Harnett County
108 EAST FRONT STREET
LILLINGTON, NC 27546
Phone:
Fax:

SUBJECT: BRES1901-0032
BUILDING RESIDENTIAL

Here are the results of all Inspections located at **93 JOEL WAY:**

ROOF TRUSS LAYOUT

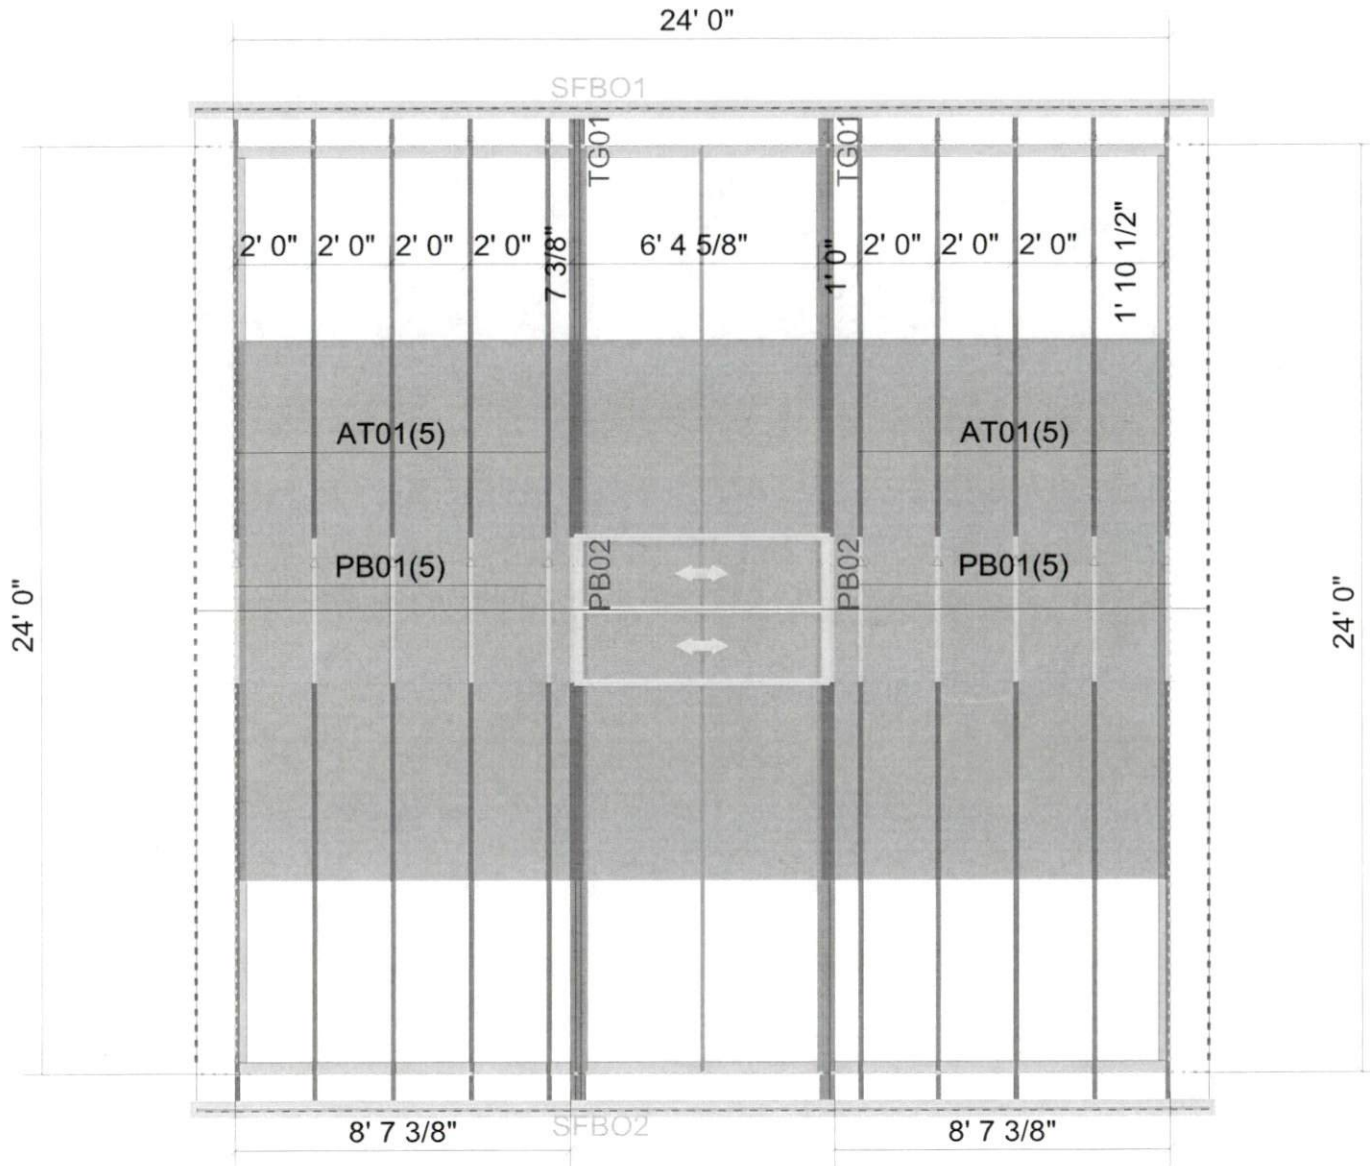
Inspector TSG changed the inspection assignment from TSG to SBL
Nail both sides stud columns below triple girders 12" oc . Strap stud columns both sides garage doors 2" square washers in wing wall and wall left of door Add anchor bolt rear wall left side Proper nail pattern on triple girder both sides Left side truss next to triple girder needs hurricane strap. Unable to locate Uplift information for triple girders. Verify no strapping needed Need taller ladder to access second floor for inspection Add king stud both sides garage door
